From: Geoff Thorpe <[REDACTED]>
Sent: 27 June 2019 10:59
To: Planning
Subject: Applications AB/48/19/PL and AB/49/19/L - for the attention of Mrs Gardner

Having read Martyn White's planning response to the above applications, posted on the Arun planning portal, please can I, on behalf of the applicant confirm/ advise as follows:

terrier firma

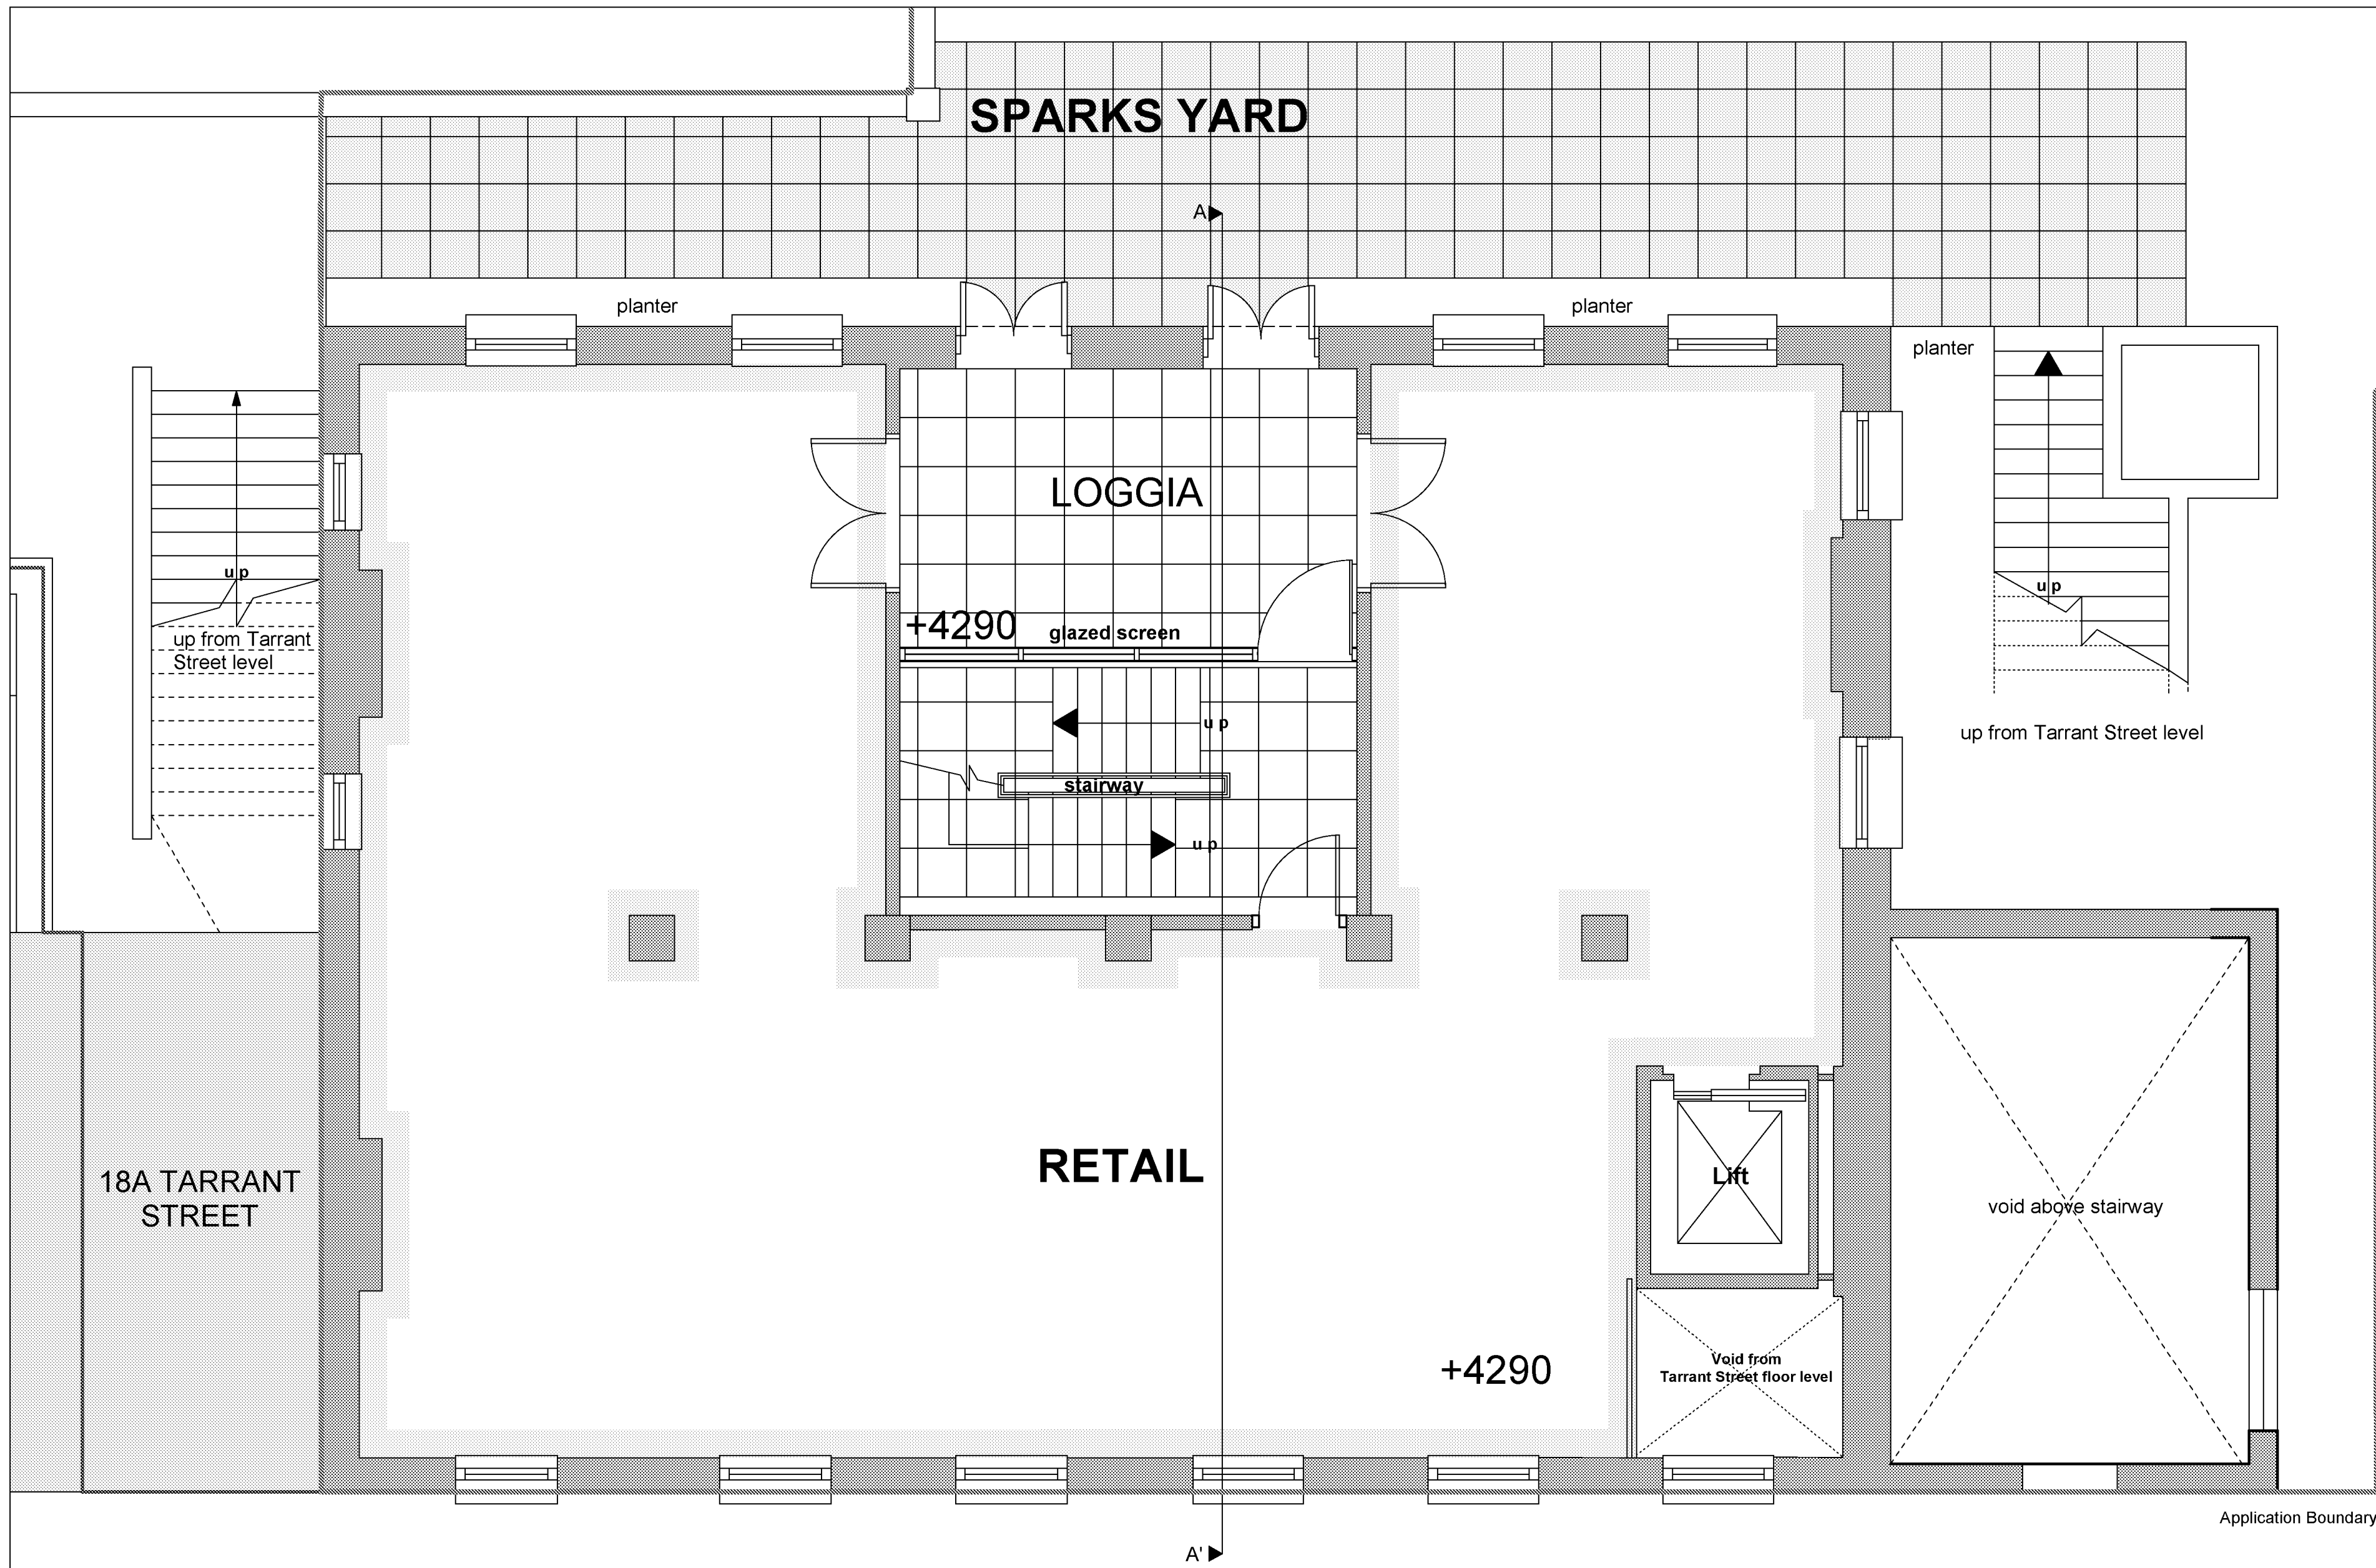
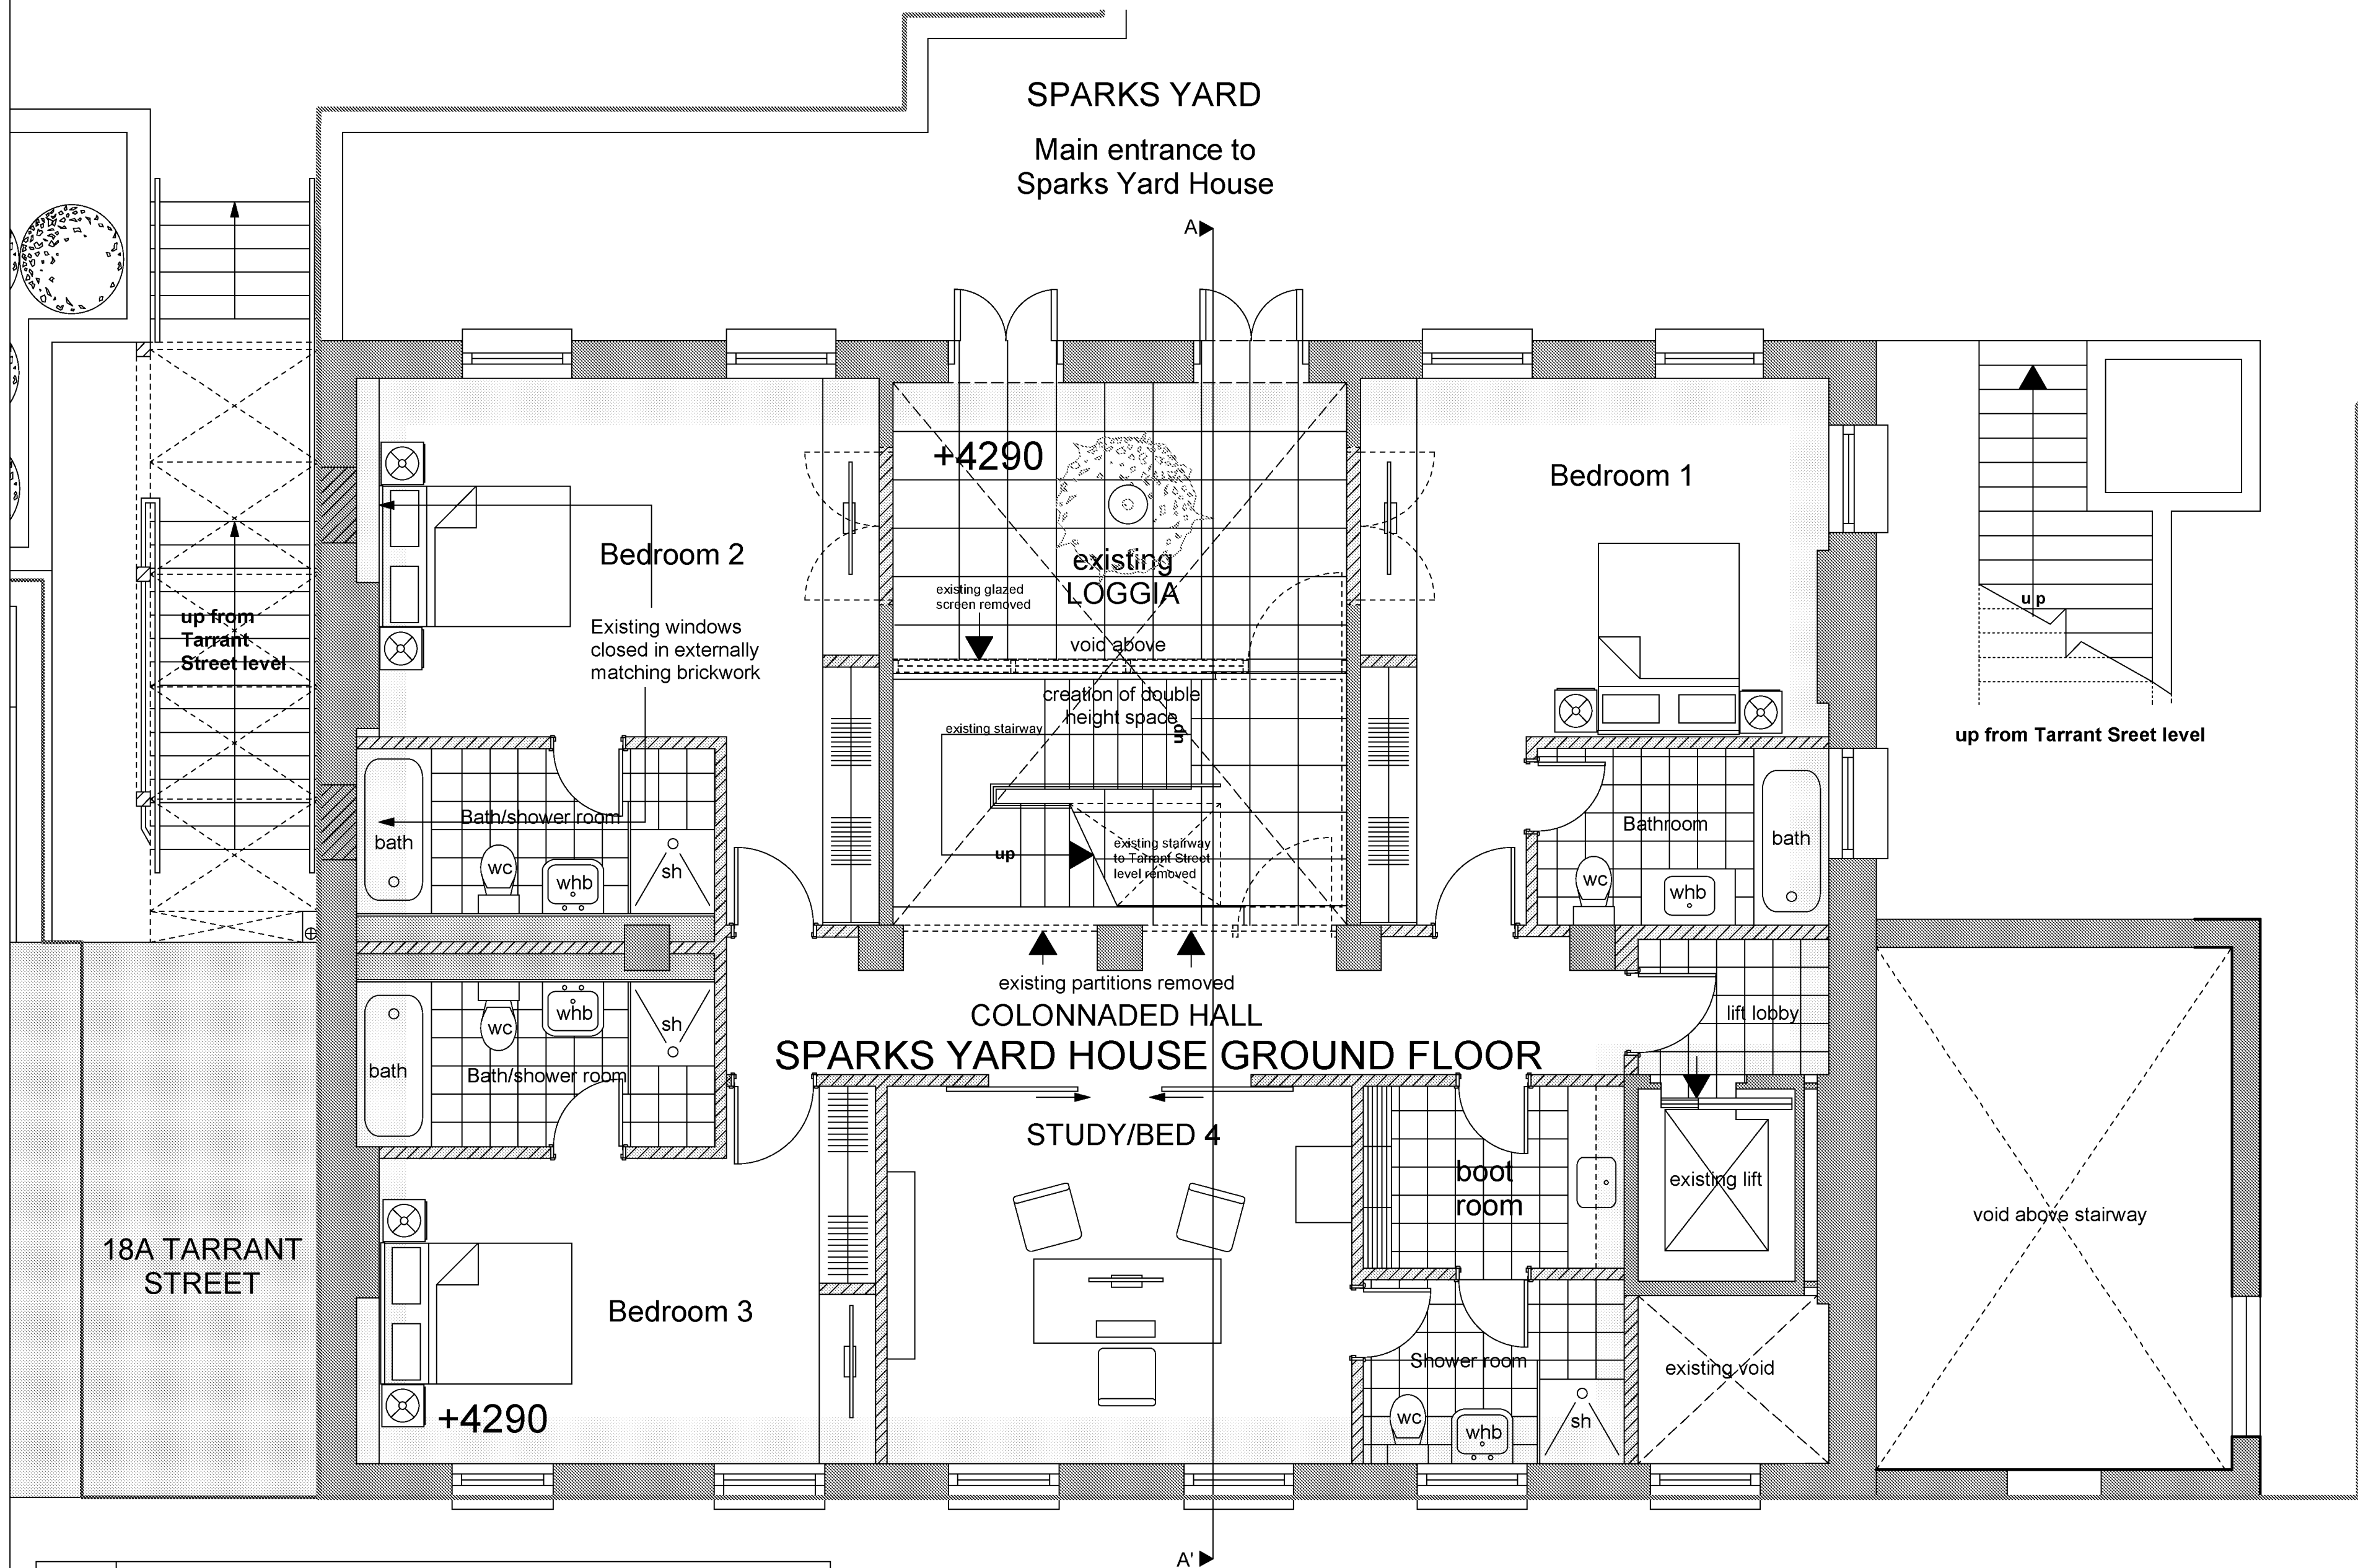
2. I am delighted to read the concerns relating to the lining of the external brick walls with insulation and plasterboard. We do not wish to do this and it was only included in the proposal in order to satisfy the inevitable thermal insulation requirements of building regulation approval. I confirm therefore that we wish to amend our applications in order to remove all proposed external wall linings to the upper two floors of the buildings and will seek an agreement to relaxation when the building regulation approval

application is made, citing its unacceptability for inclusion within this listed building. Would you like us to submit amended drawings to cover this or can this be covered by a potential condition?
